Stormwater Drainage Report comments - Copy.pdf Markup Summary

Bret Dilts - DPW Engineering (3)

APPENDIX E

HYDRAULIC COMPUTATIONS

100-year Emergency Overflow Detention Pond

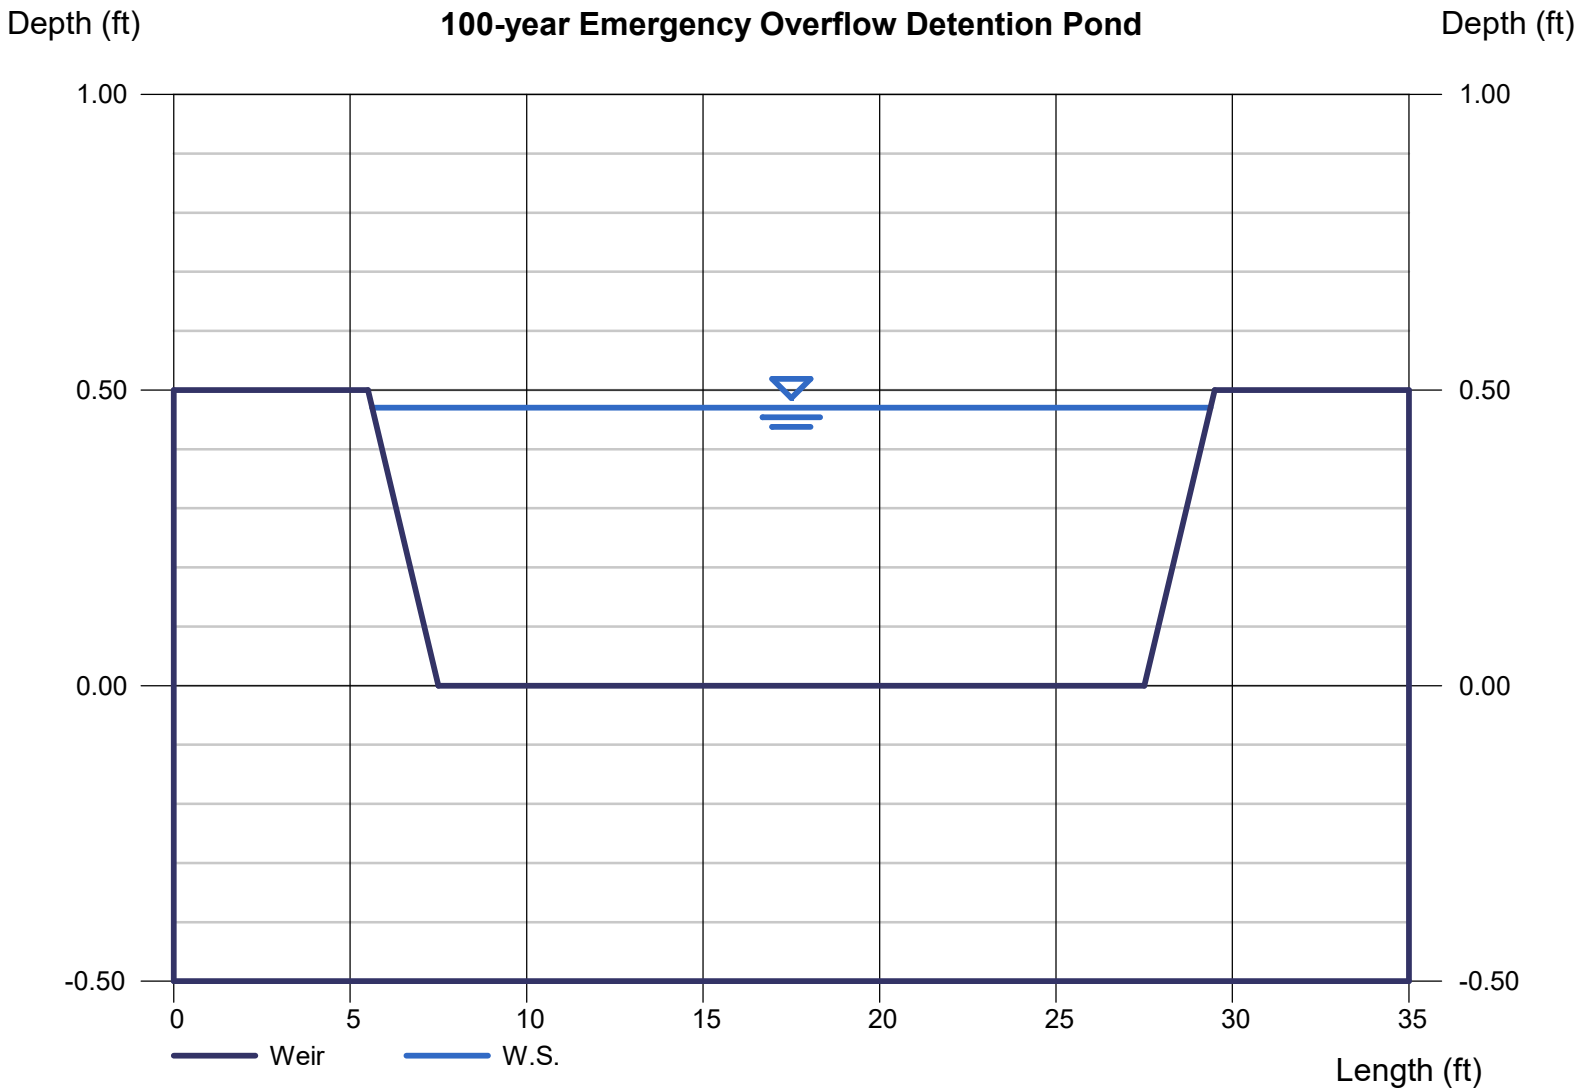
Please clarify what the water surface is if the 100yr surface is marked in red, when is the spillway activated?

TAIT Response:
Side slopes have been changed to 4:1.

The lower water surface is the operational 100-year storm water surface elevation. In the regular operating conditions, it discharges over the top of the outlet structure but does not discharge through the emergency overflow spillway. The upper surface has been labeled as the Clogged Outlet condition for the 100-year storm and flow is conservatively take as the sum of peak flows across the site for the 100-year storm. This surface would only be applicable to a 100-year storm paired with an emergency situation like a clogged outlet. Storms exceeding the 100-year storm may also over top through the emergency overflow spillway.
